MY GARAGE @ NORTHCREST

RECORD DRAWINGS

Grading Erosion Control Plan

My Garage @ Northcrest
Site Detail Plan - Record Drawings

6 Trapezoidal Typical Swale Section
C602 NOT TO SCALE

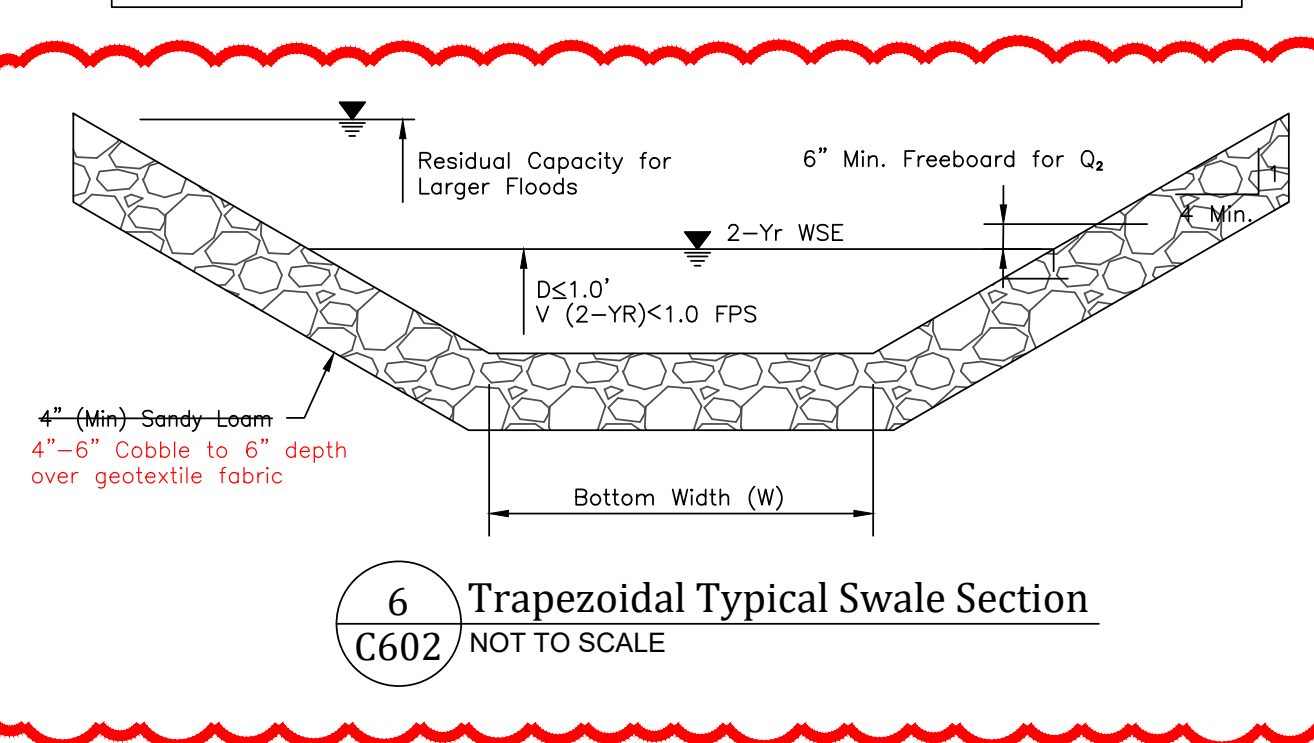
PA Punchlist Item:
"Trapezoidal swale. Plans call for grass lined swale. Contractor is wanting to install riprap swale."

As-Built comment: please shoot me an email if the contractor decided to leave this as grass lined. Otherwise redline this as riprap if that's what the contractor did in the field. We'll also need calcs to show that the riprap is sufficiently sized for the flows.

3 Section A-A
C602 NOT TO SCALE

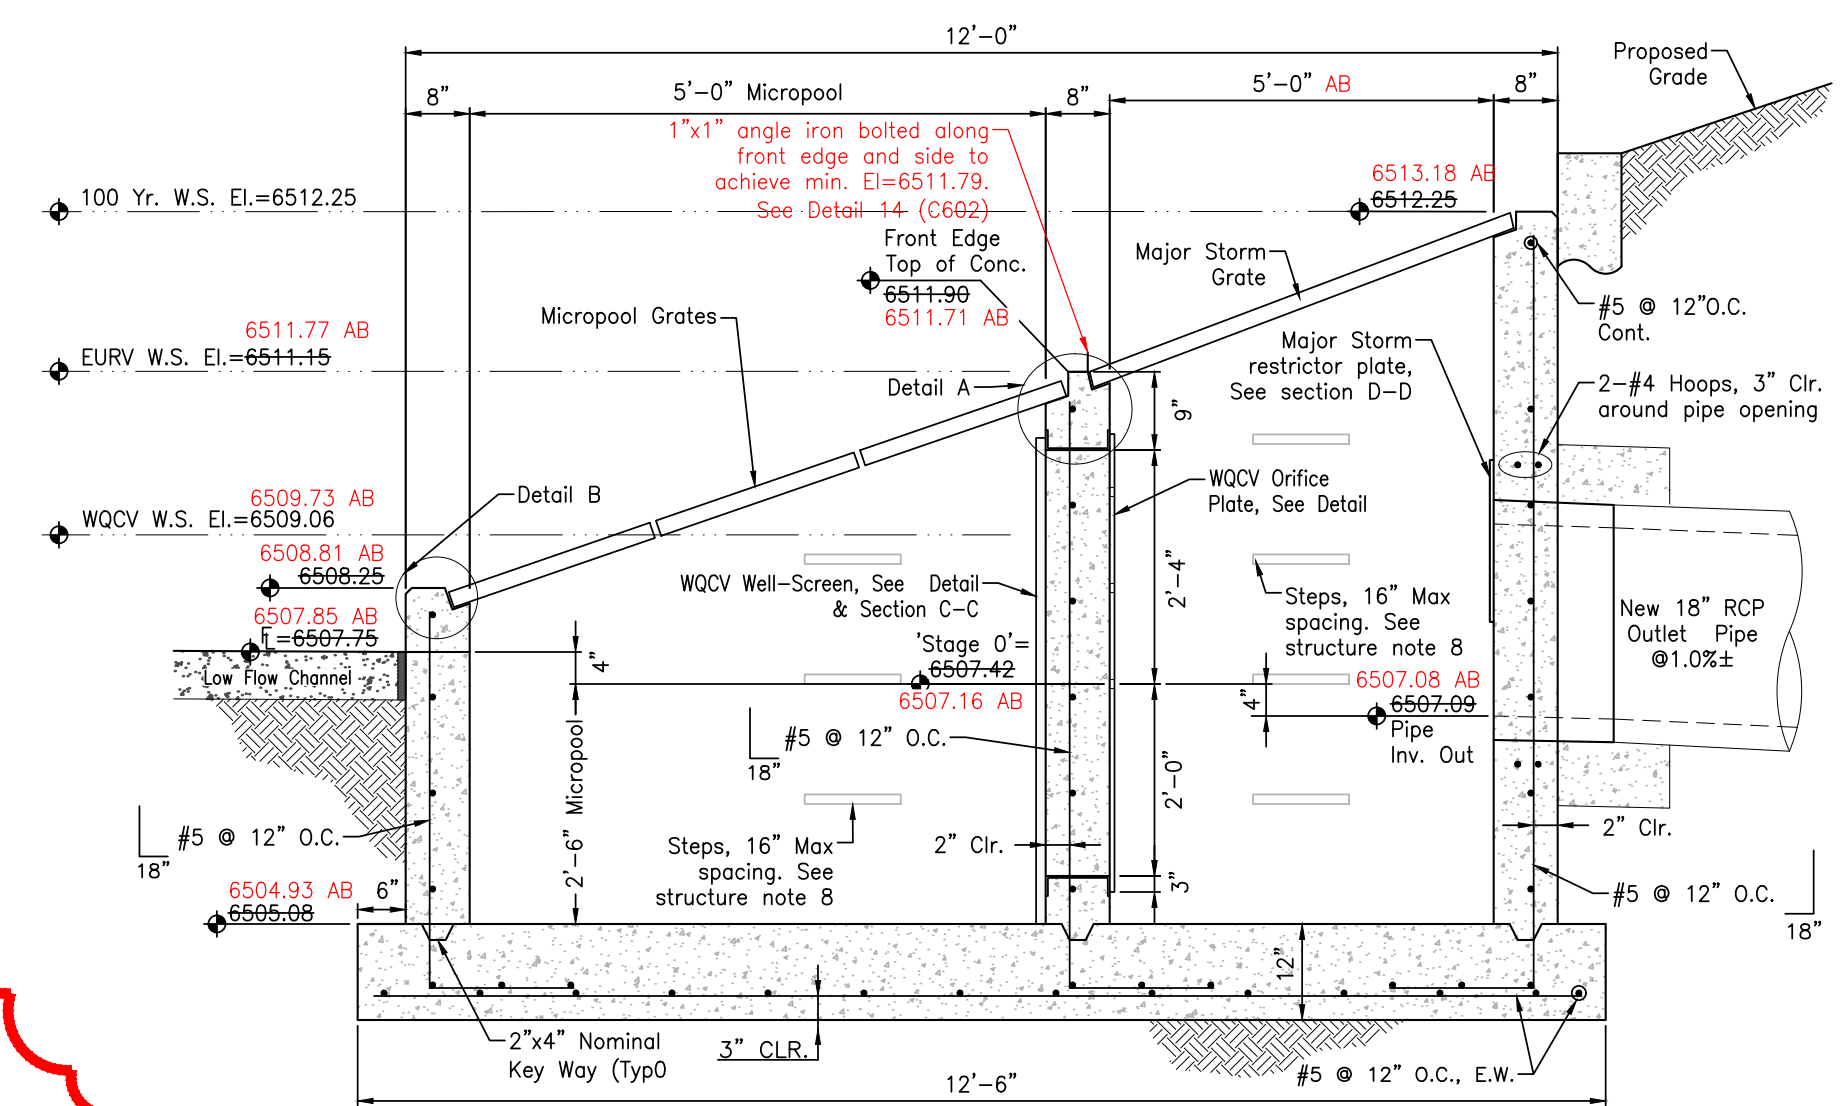
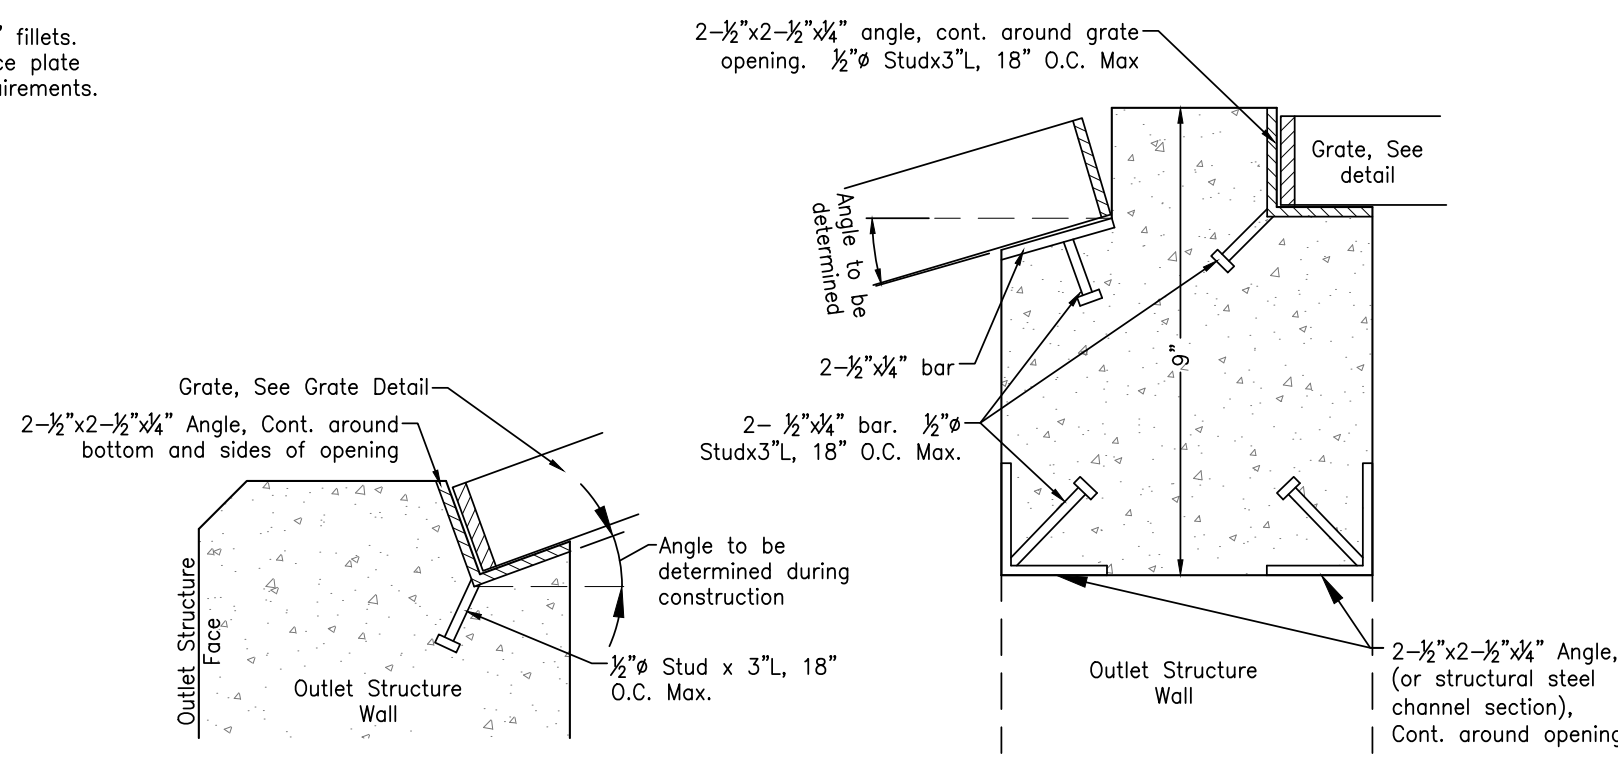
Calcs show this at:
6507.16 + 4.55 = 6511.71
Or did you mean to input 4.63 into Overflow Weir Front Edge Height on the calcs?
